Date: April 24, 2018

From: Charles K. Cothorn, P.E.

Subject: Springs at Waterview

This memorandum has been prepared to provide response and clarification to the GMS letter dated February 22, 2018. The comment is listed followed by the response. Please find attached 3 sets of the revised plans for the above referenced project for your review along with a copy of the plat. One of the sets and a copy of the plat has been provided to GMS, Inc. for their review.

PDF: 15 - STORM C & D PROFILES.PDF

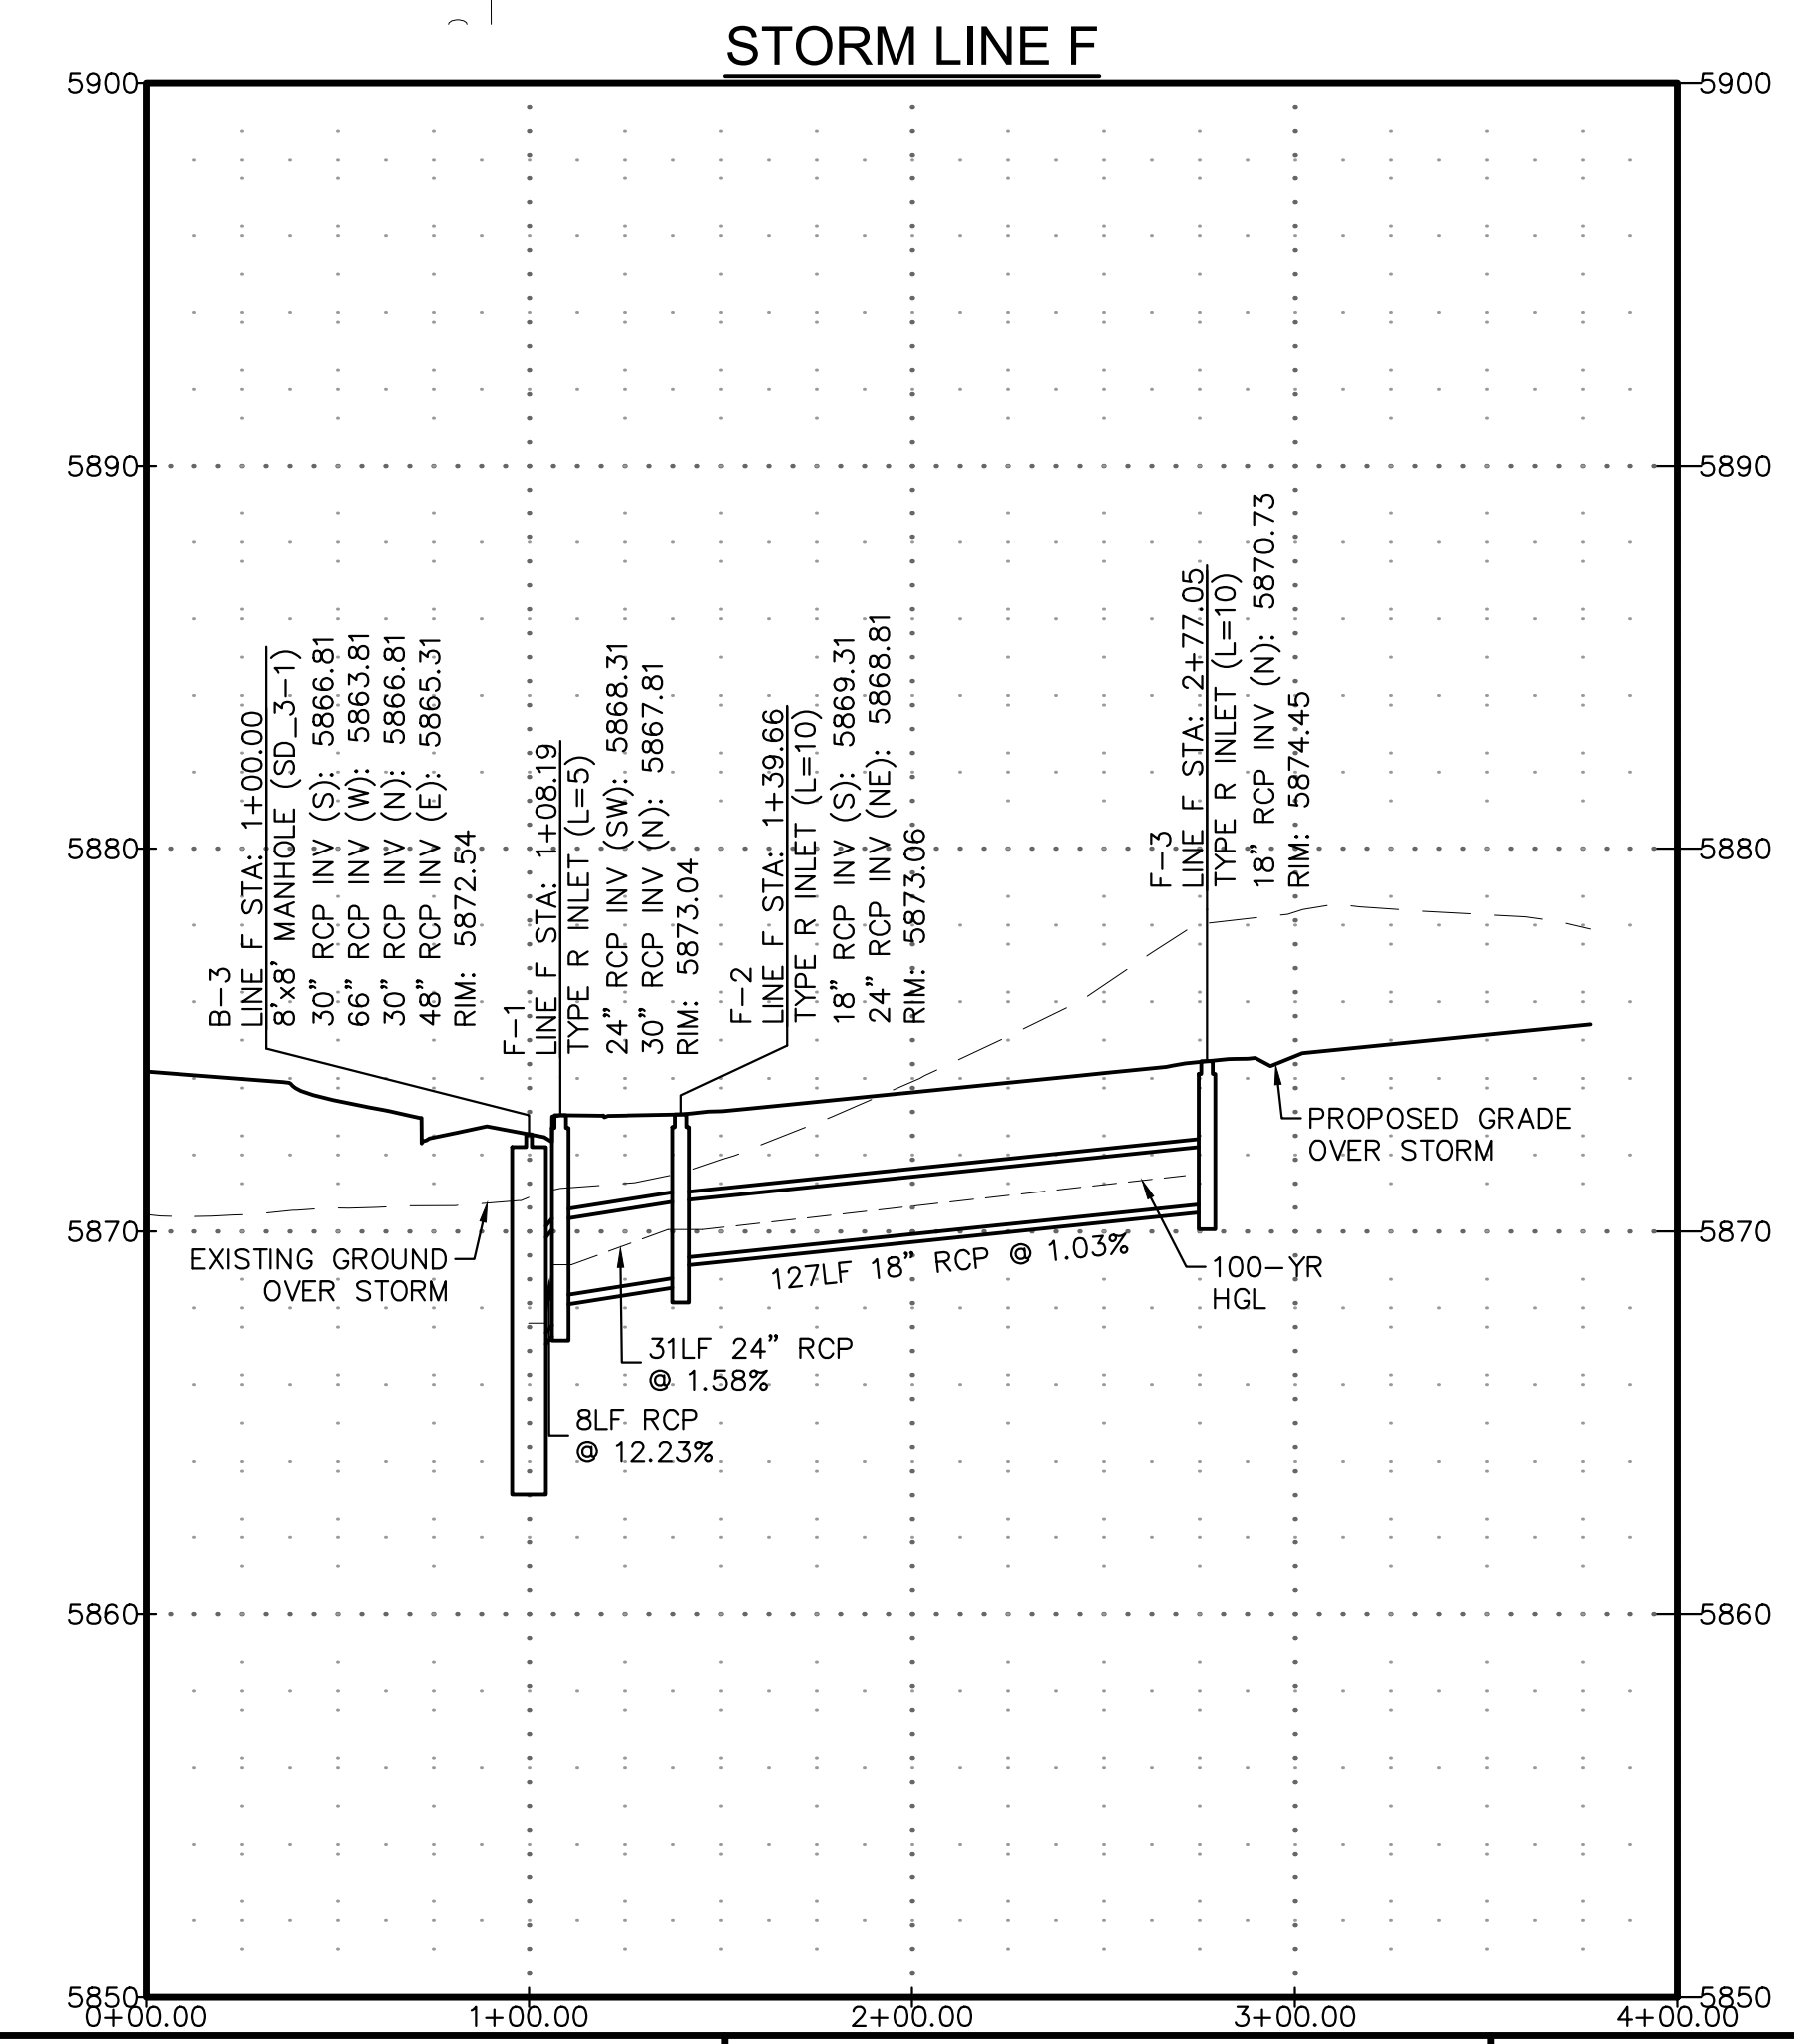
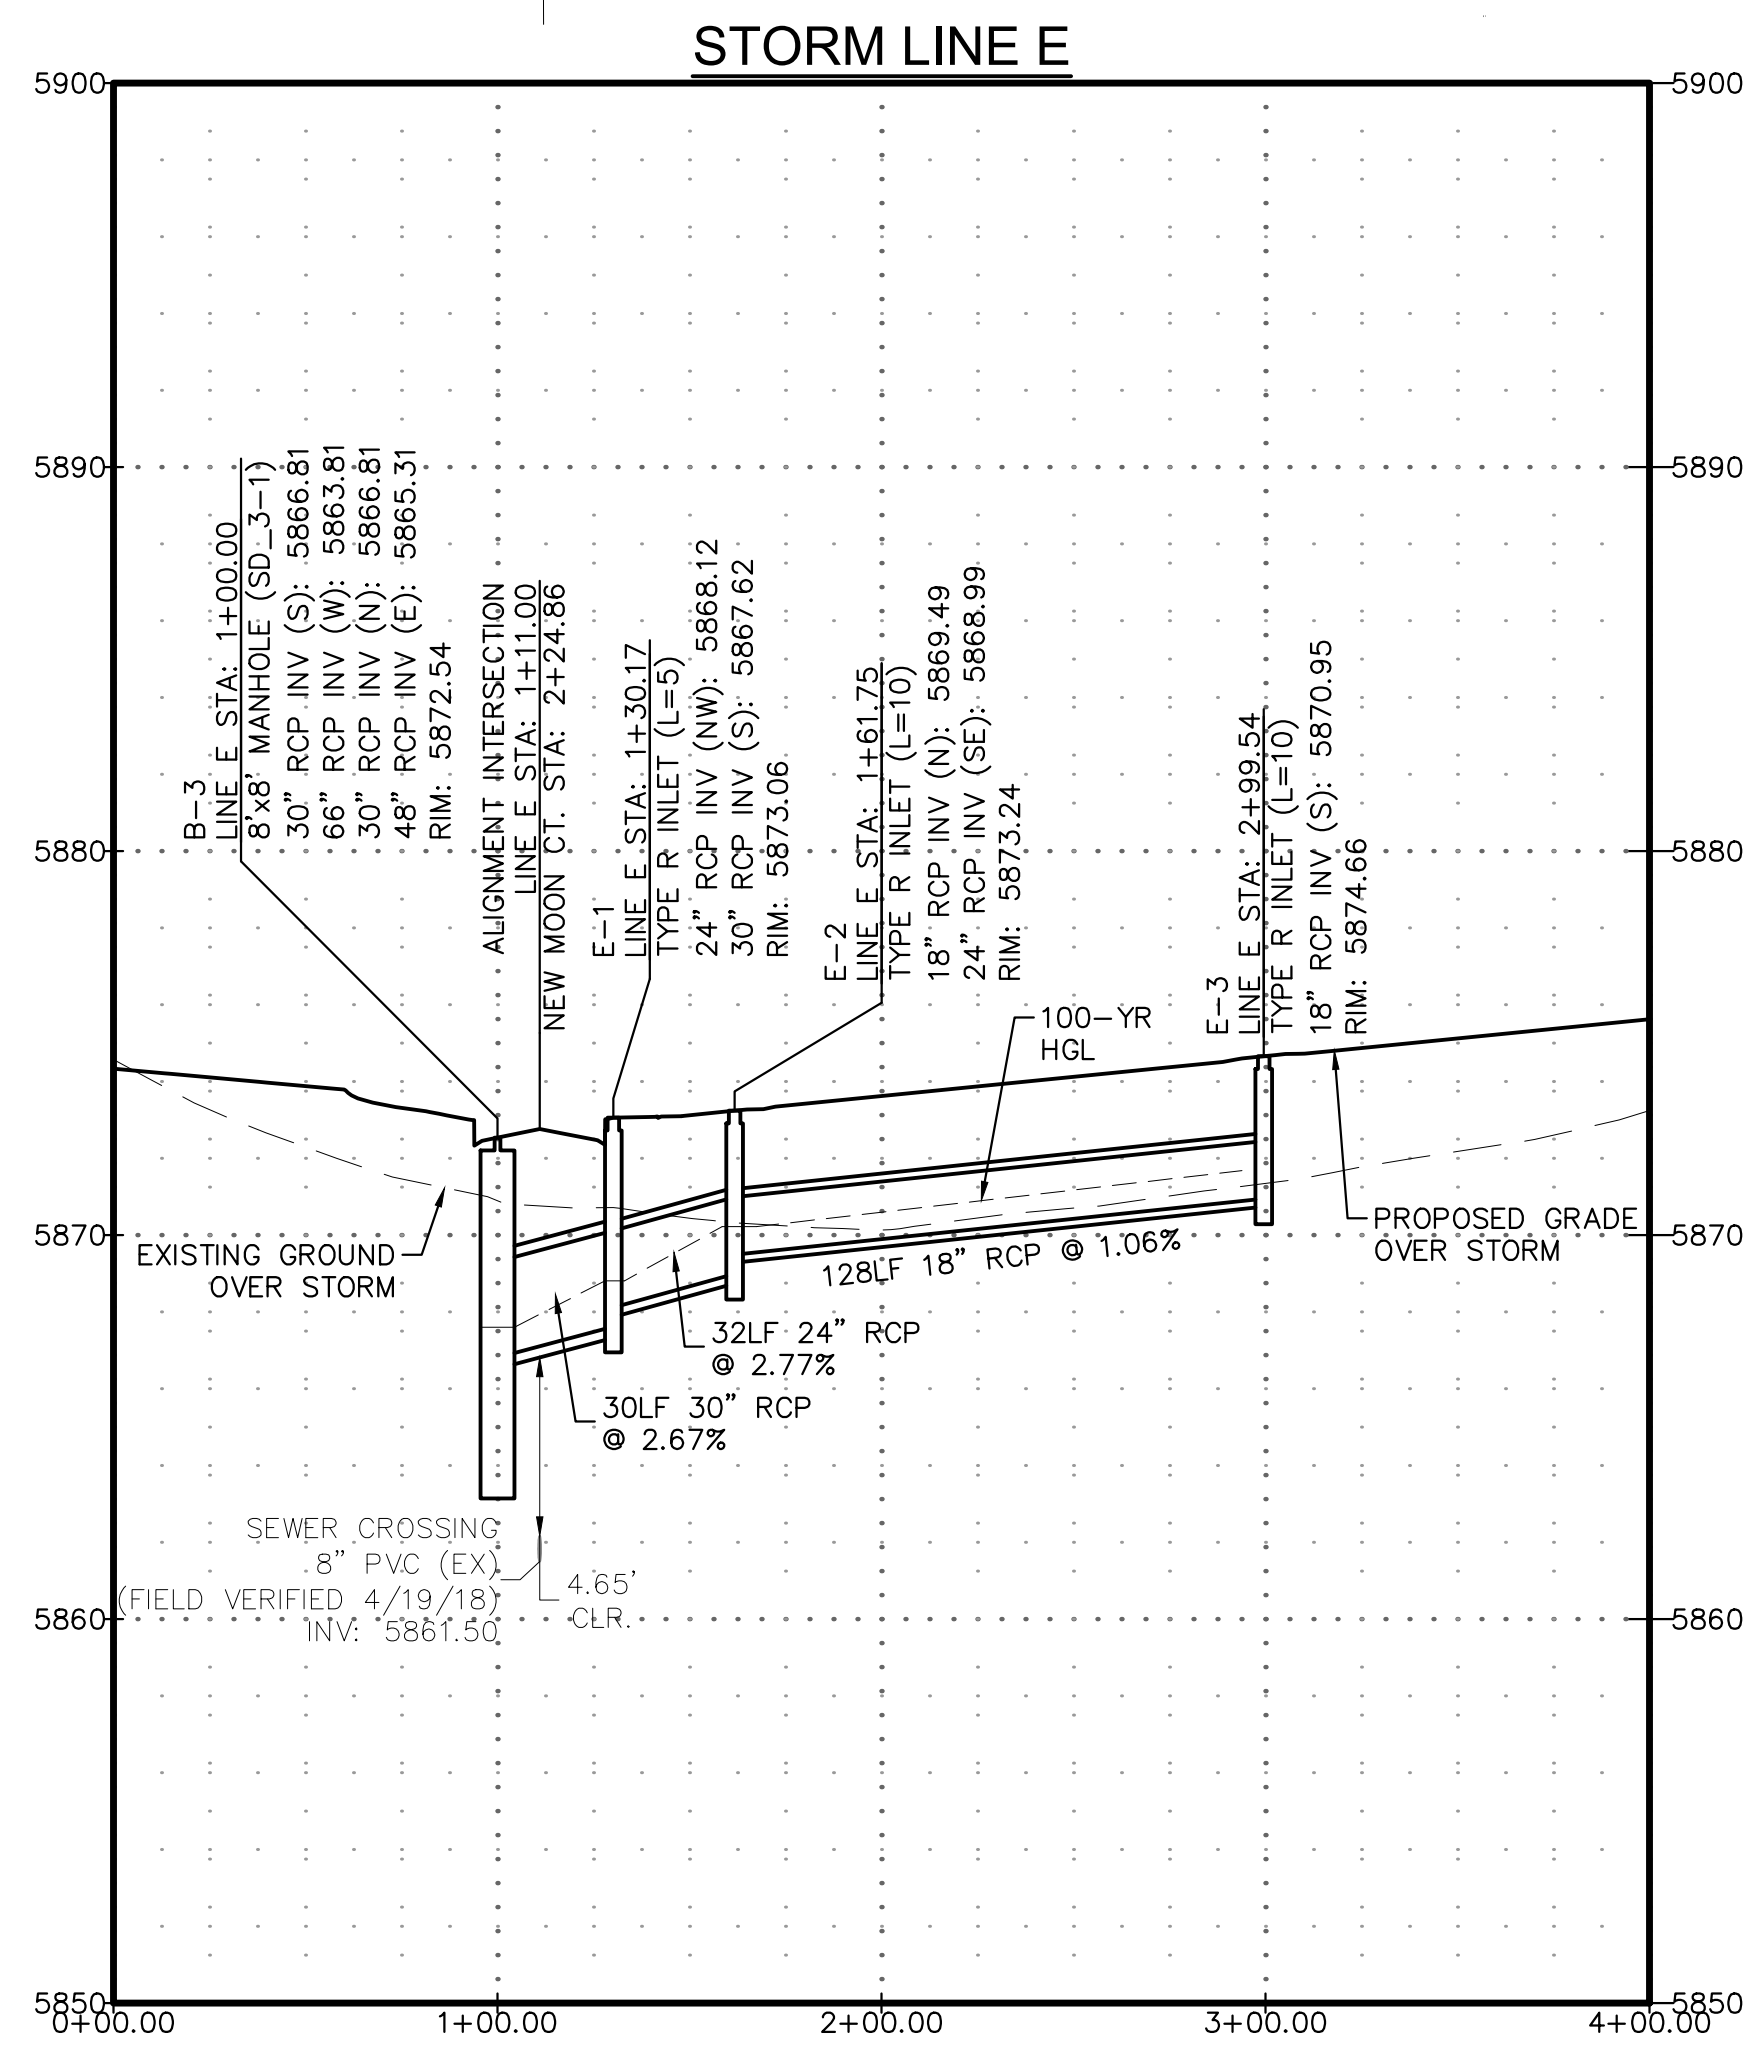
1. In order to comply with District's water service depth requirements and vertical separation requirements from sewers, please provide and indicate the use of water service sleeves where the water services will cross under Storm Lines C and D. Provide complete construction details.

DSE Response: Water service line callouts added to have service sleeves to be installed on Lots 9-10, 24-26, 49-50, and 71-73. Standard detail for sleeved crossings added to Sheet 5 of 11, titled Master Utility Plan.
